Application no: H23/1155/02

Description: Proposed two storey extension and double garage

Location: Holly Tree House
Malten Lane
Whaplode

Amendment: Omit two-storey southern extension
Dwg.Nos. 1759.02.3A & 1759.02.4A

FIRST FLOOR

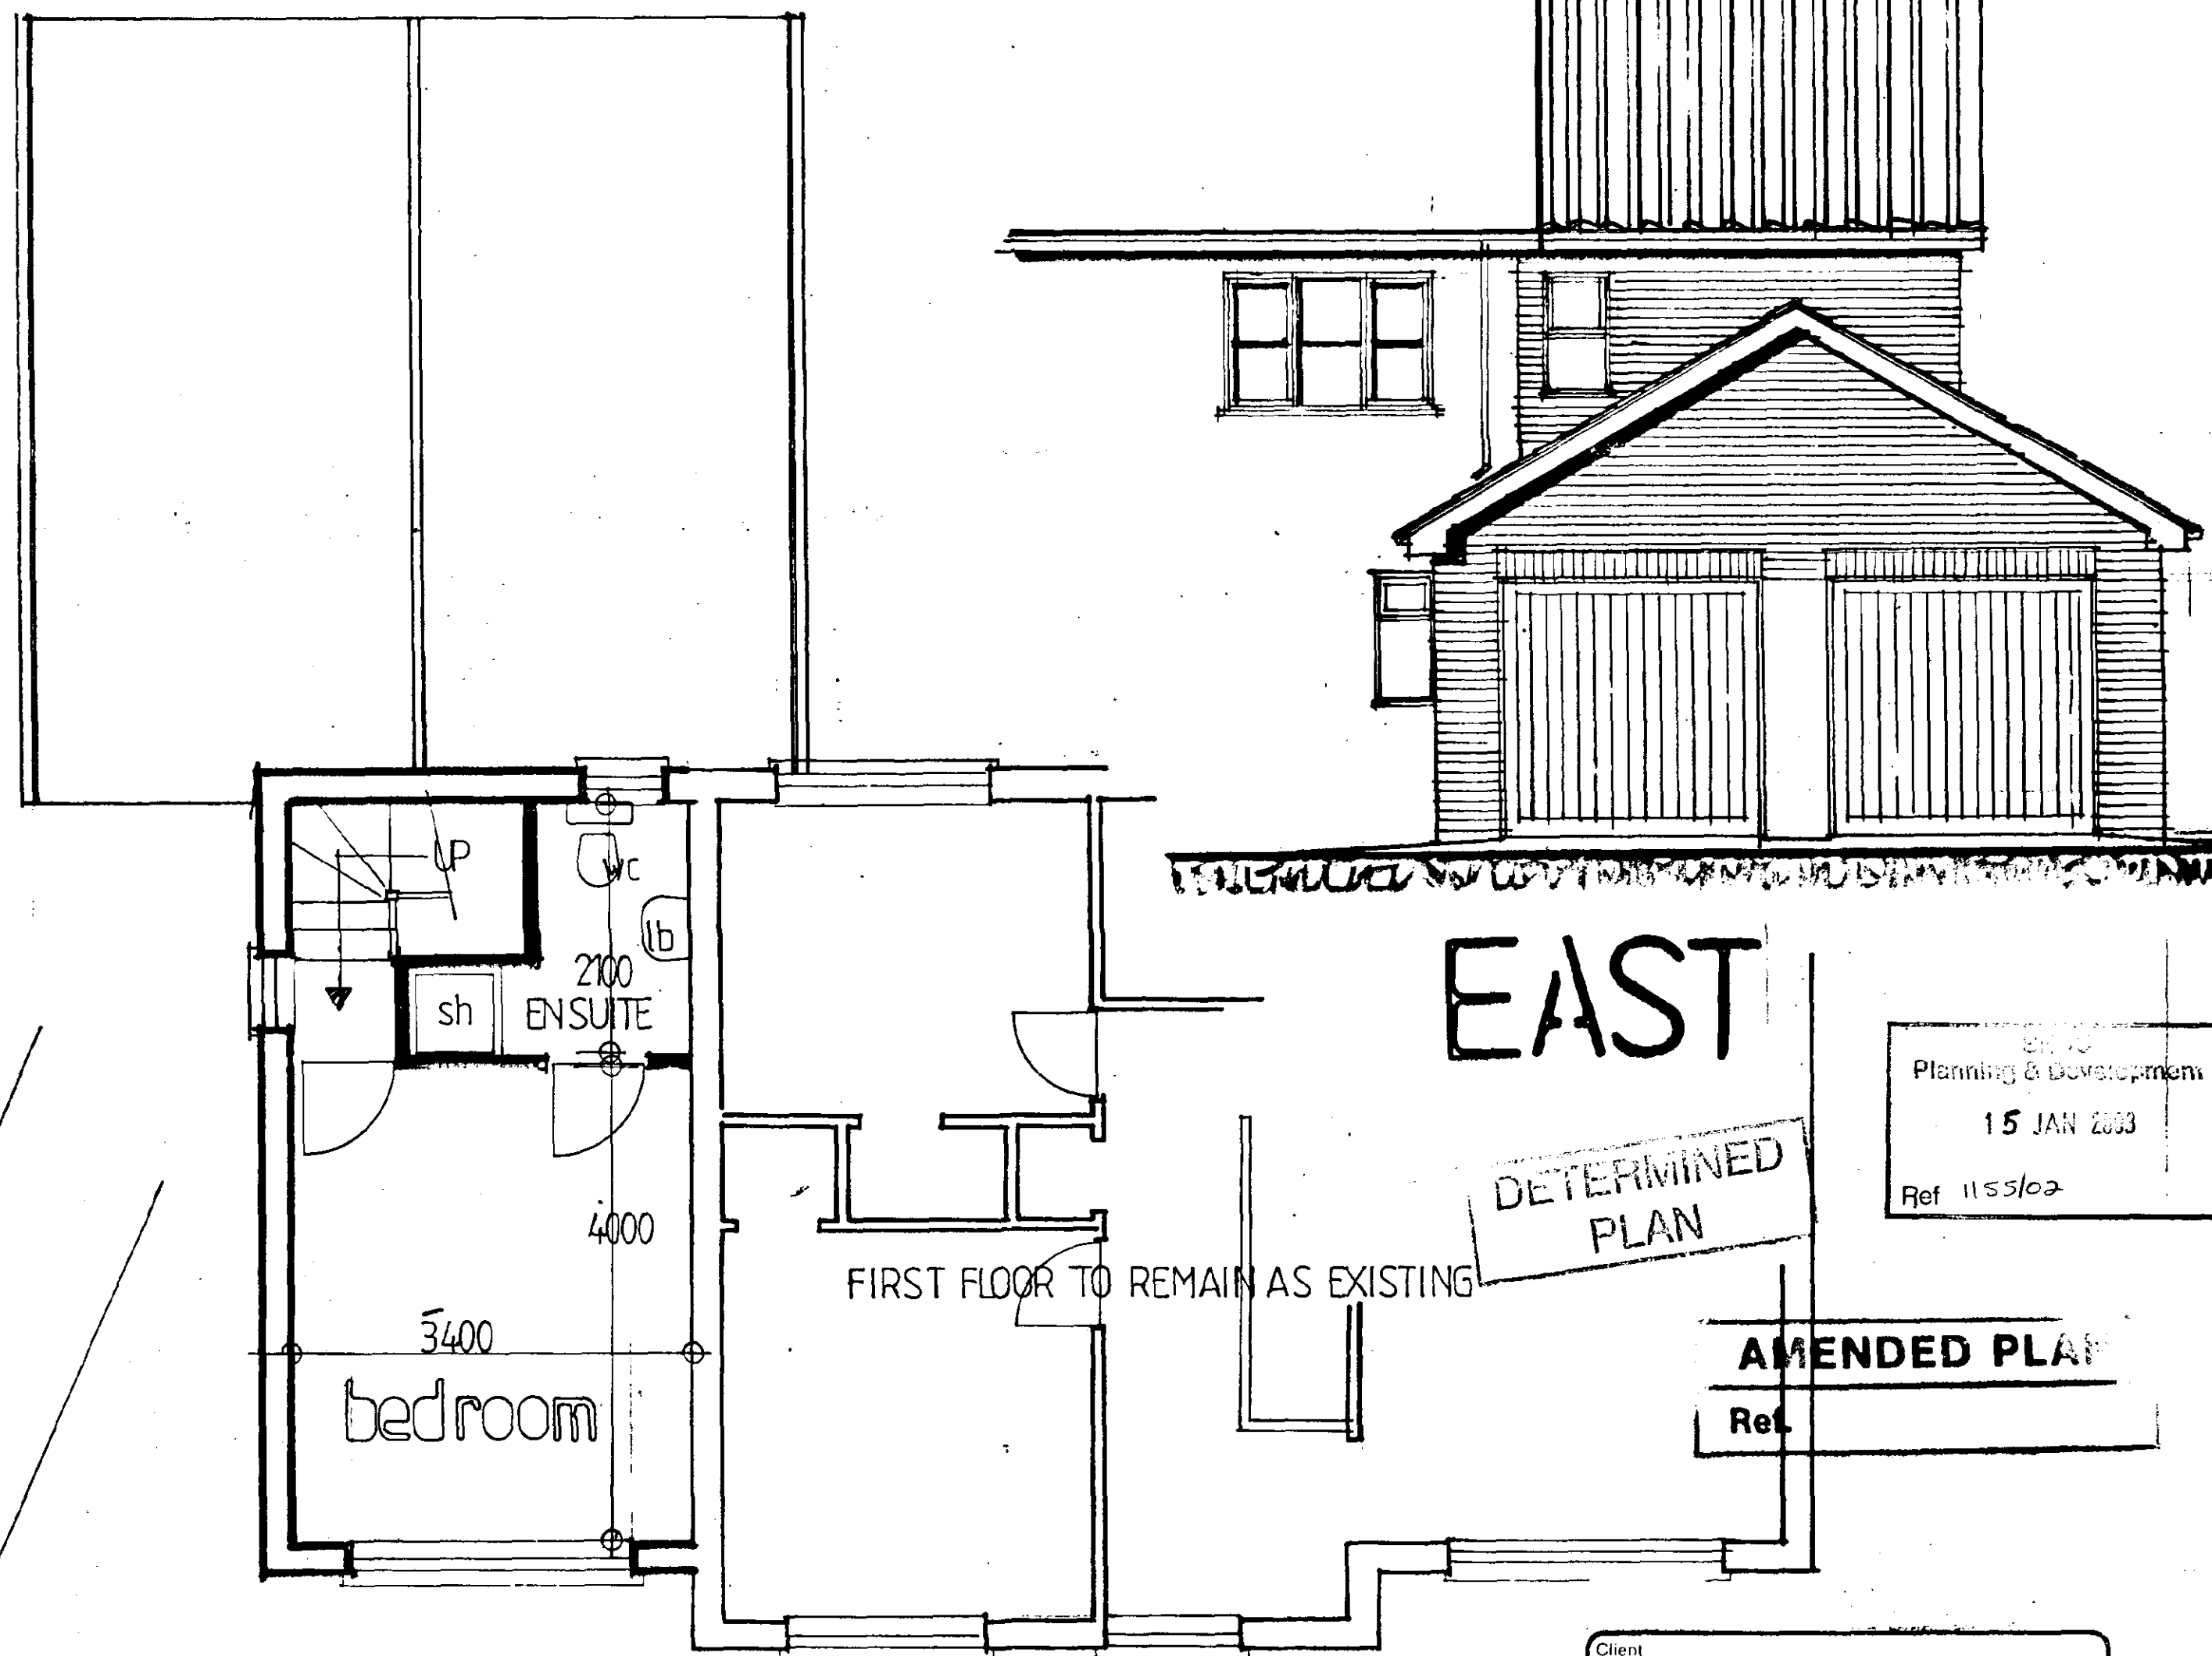
Further to our Planning Application and subsequent telephone conversation with your Mr. Gedney regarding the above, we have discussed the application with our client, Mr. Bhondi and he has decided to omit the two storey southern extension completely.

Please find enclosed two copies each of drawings number 1759/02/3A and 4A showing the proposed revisions for your consideration.

Amended plans have now been received which omit the extension on the southern side of the building. Also, the only window now proposed on the rear elevation at first floor level is associated with an ensuite and will therefore be obscure.
